Recommendation Report for Planning Permission for Works or Extension to a Dwelling

REF NO: AW/151/19/HH

LOCATION: 131 Manor Way
Aldwick
PO21 4HL

PROPOSAL: Erection of single storey rear extension (resubmission following AW/260/17/HH).
This application affects the character & appearance of the Aldwick Bay Conservation Area.

sheet 1 of 2

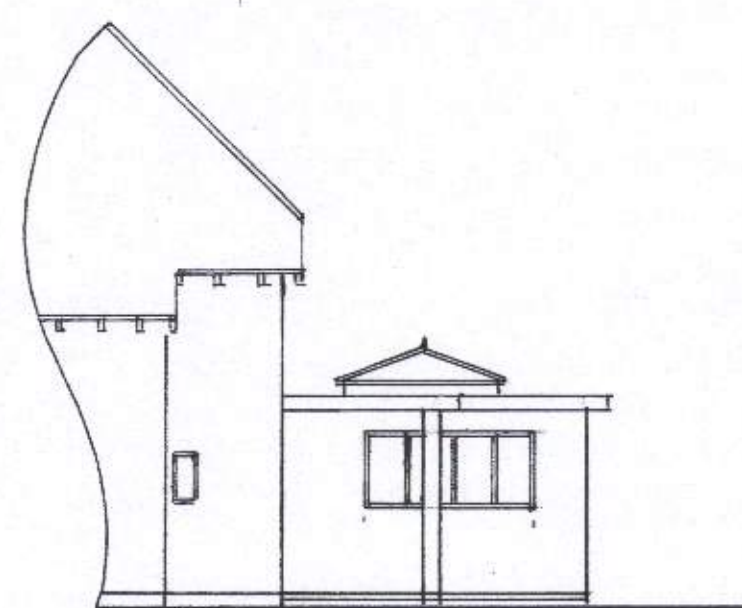
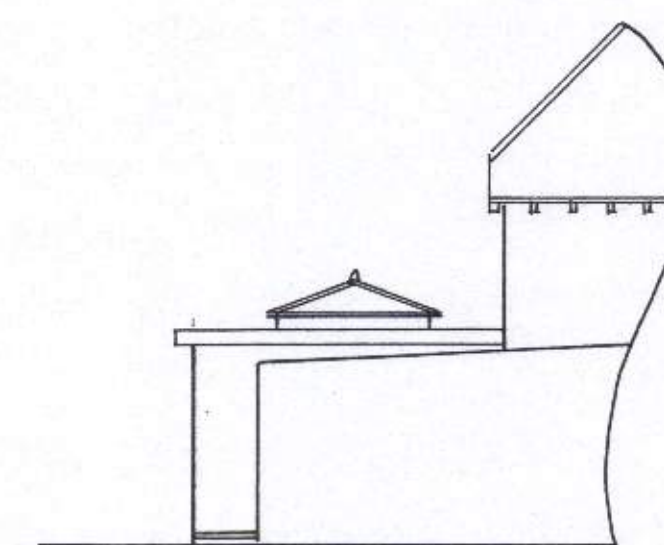
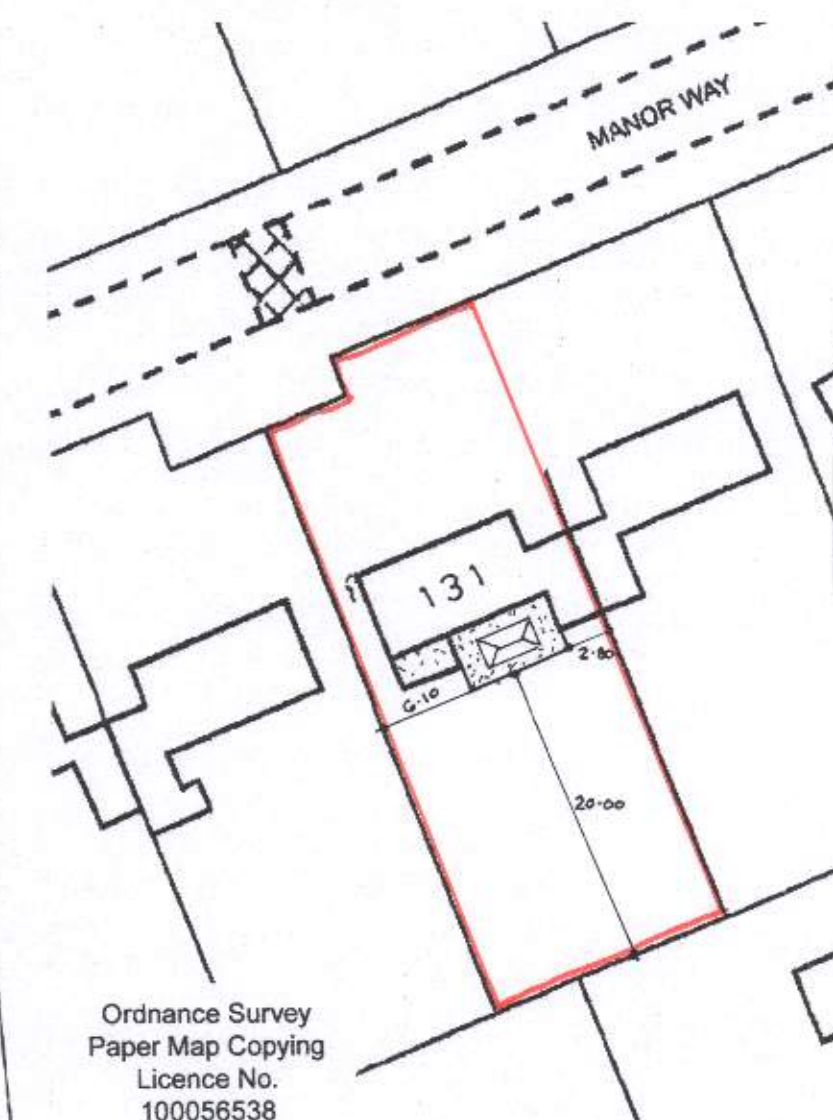
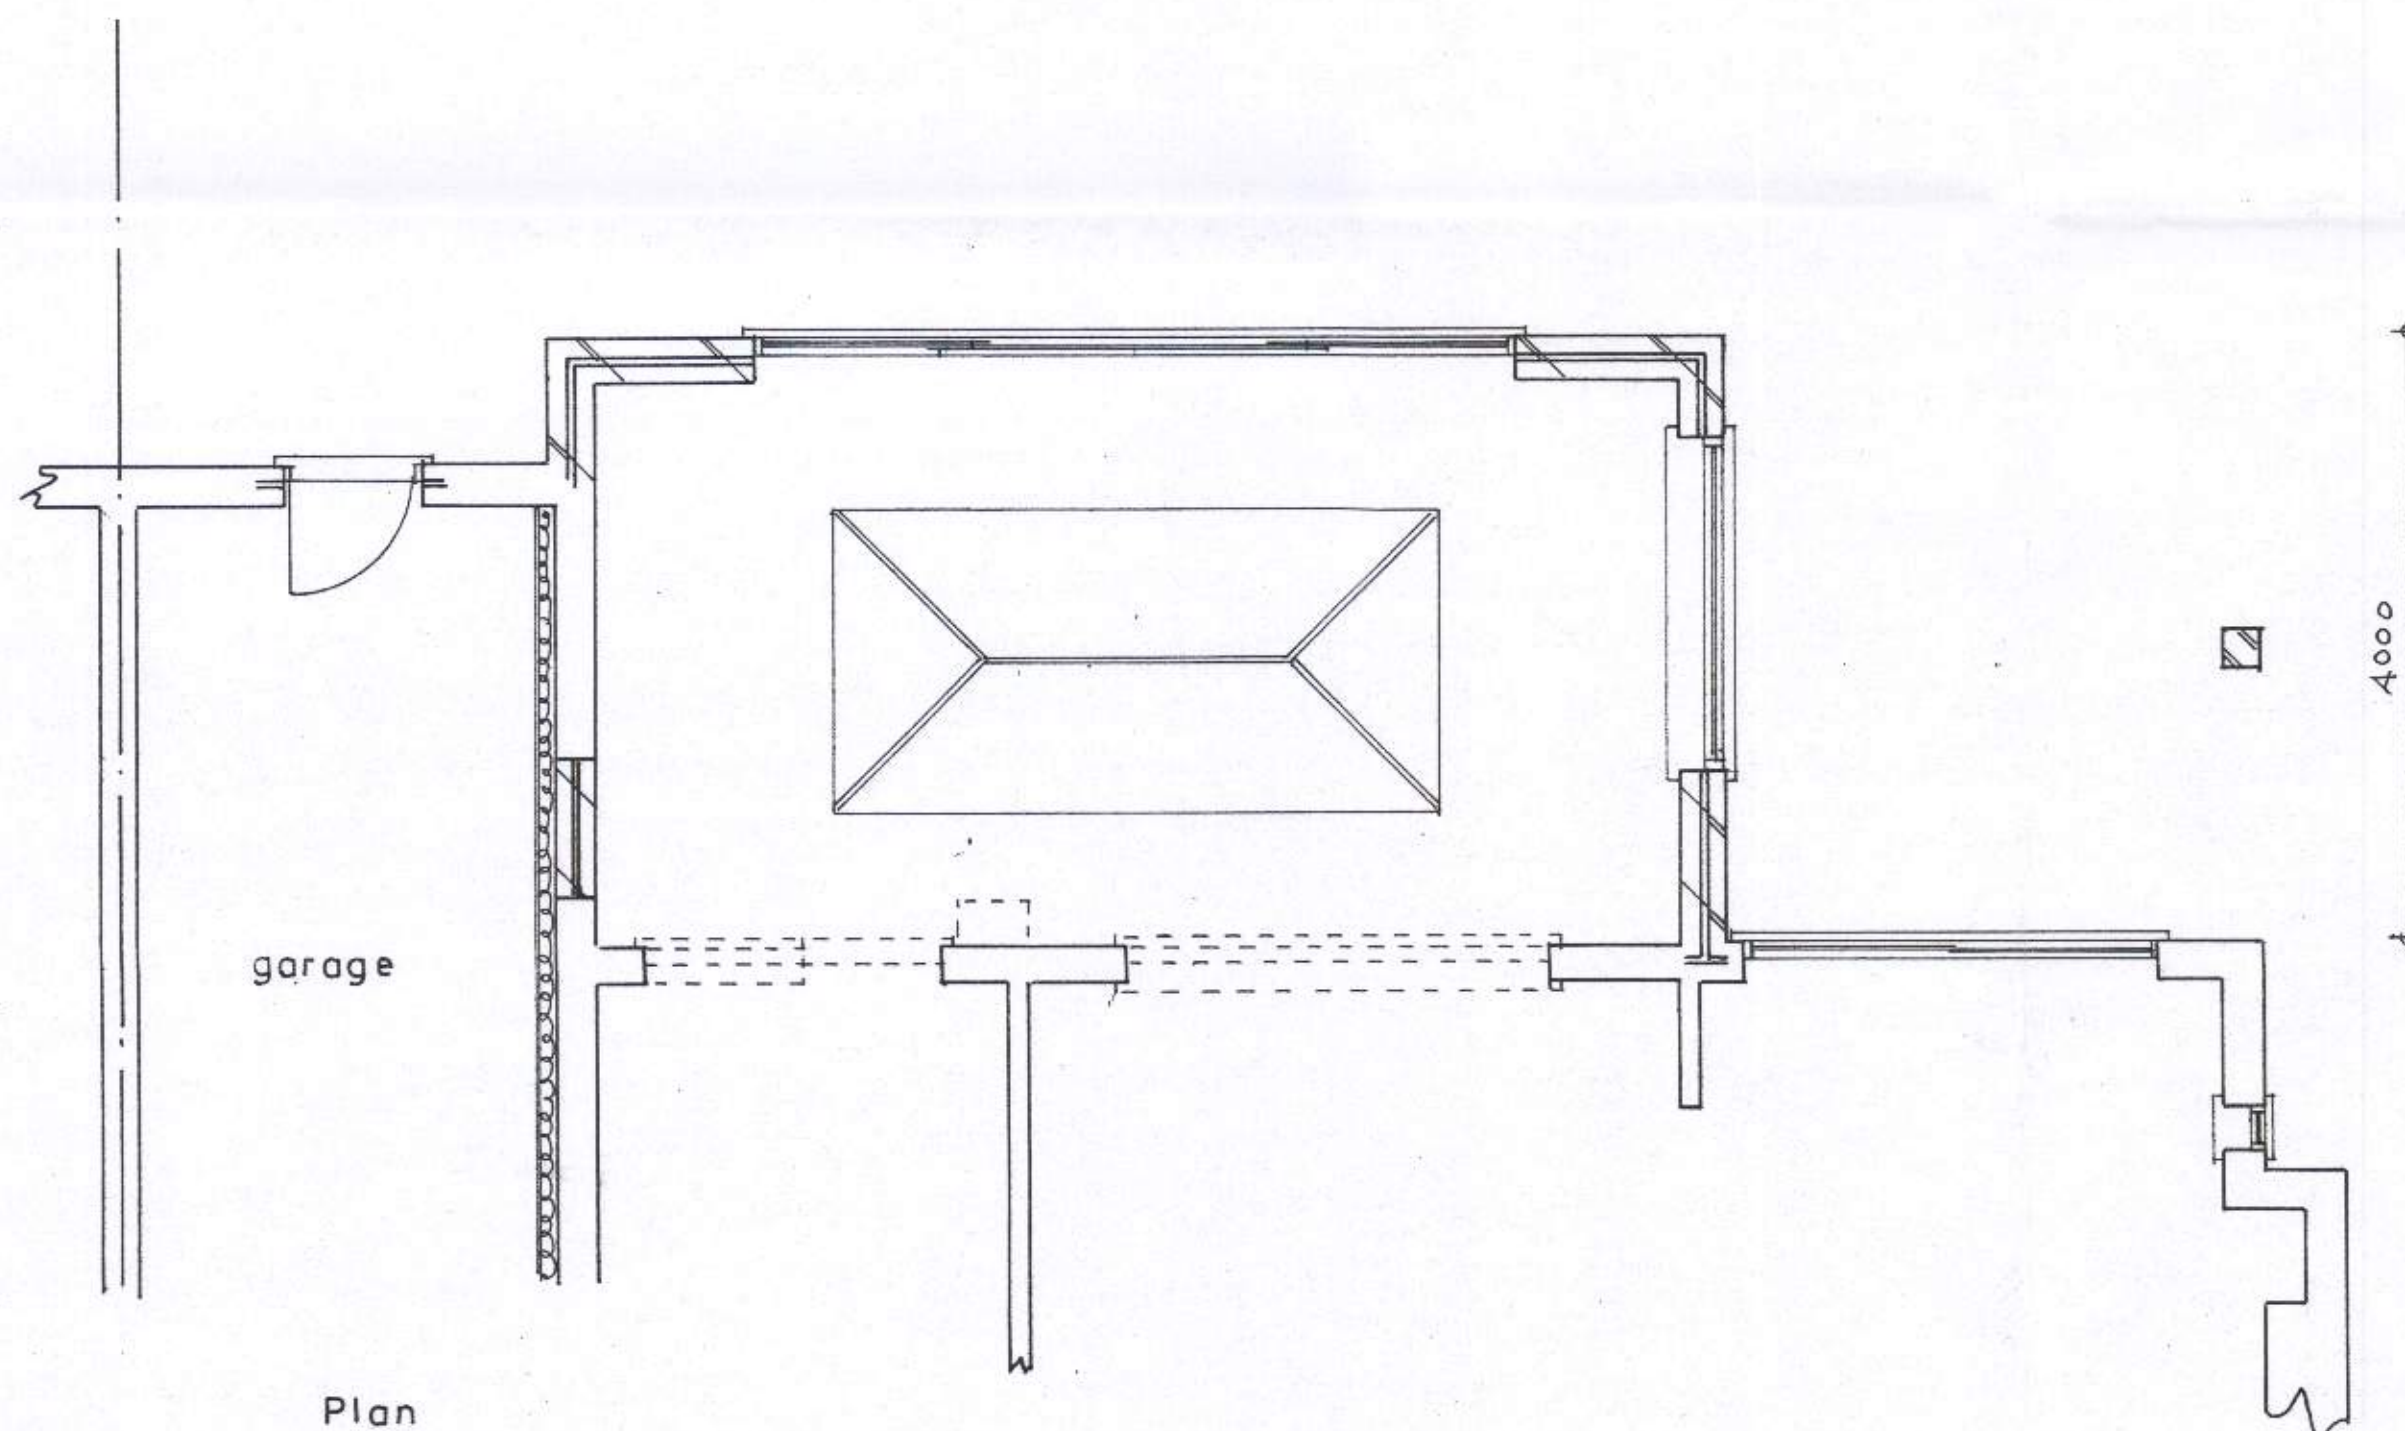
The applicant seeks planning permission for the construction of a rear extension to the established dwelling. The proposed rear extension will measure approximately 7.8m wide, 4m in depth and be built to the proposed height of 2.8m and a roof lantern that protrudes a further 0.8m.

The proposed rear extension will be located 20m from the southern boundary, 2.8m from the eastern boundary and 1.5m from the western boundary. On the southern elevation there are 4 No. proposed sliding doors. On the proposed western elevation there are shown to be 4 No. windows. On the roof there is 1 No. proposed roof lantern that measures 4m by 2m with a proposed pitch height of 0.6m.

The current application has differed from the preliminary application with a reduction in size, removal of a pitch to the roof and removal of a window. It has the addition of a sky lantern on the flat roof. These changes are deemed to be acceptable and improved.
